RE: McGrath Short Plat, SP-08-00050

SUBJECT: McGrath Short Plat SP-08-50

Our department has reviewed the short plat application and has the following comments:

McGRATH SHORT PLAT - NO. SP-08-00050
LOCATED IN SECTION 32, T-18 N, R-20 E, W.M.
KITITITAS COUNTY, WASHINGTON

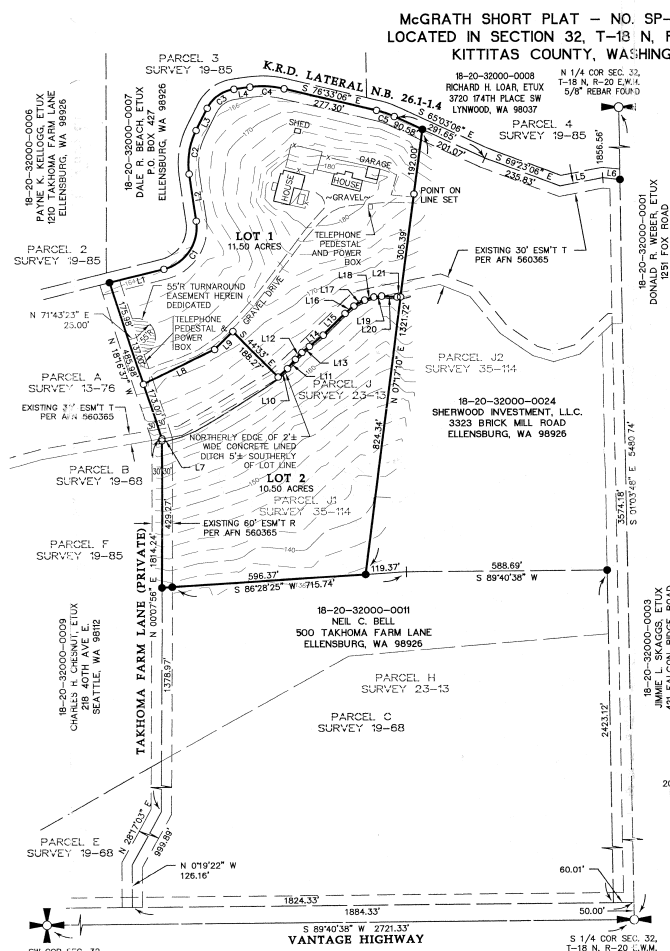
- All development must comply with the 2006 International Fire Code.
- The area designated as a turn-around located at the north end of the driveway will suffice.

3. Private Road Improvements: Access from Vantage Highway to a turnaround shall be constructed as a Low-Density Private Road. See Kittitas County Road Standards, 9/6/05 edition.

- a. Access easements shall be a minimum of 60' wide. The roadway shall have a minimum width of 20', with 1' shoulders, for a total width of 22'.
 - b. Minimum centerline radius will be 60'.

- c. The surface requirement is for a minimum gravel surface depth of 6".

- d. Maximum grade is 12%.
 - e. Stopping site distance, reference AASHTO.
 - f. Entering site distance, reference AASHTO.
 - g. Maintenance of driveway approaches shall be the responsibility of the owner whose property they serve. The County will not maintain accesses.

4. Turnaround: A cul-de-sac or a hammerhead shall be constructed on the property at a point beyond the driveway to Lot 1. A cul-de-sac turn-around shall have an outside right-of-way or easement diameter of at least 110 feet and a roadway diameter of at least 96 feet. A hammerhead may be constructed with approval of the County Fire Marshal. Cul-de-sacs and hammerheads must conform to the requirements specified by the 2006 International Fire Code. Contact the Fire Marshal regarding any additional turnaround requirements.

5. Joint-Use Driveway: Access from Takhoma Farms Lane shall be constructed as a joint-use access that serves no more than two tax parcels. See Kittitas County Road Standards, 9/6/05 edition.

- a. Access easements shall be a minimum of 20' wide. The roadway width shall have a minimum width of 12'.
 - b. The surface requirement is for a minimum gravel surface depth of 6".

6. Plat Notes: Plat note number 3 shall be removed.
7. Private Road Maintenance Agreement: The applicant shall meet all applicable conditions of any pre-established or required Private Road Maintenance Agreements.
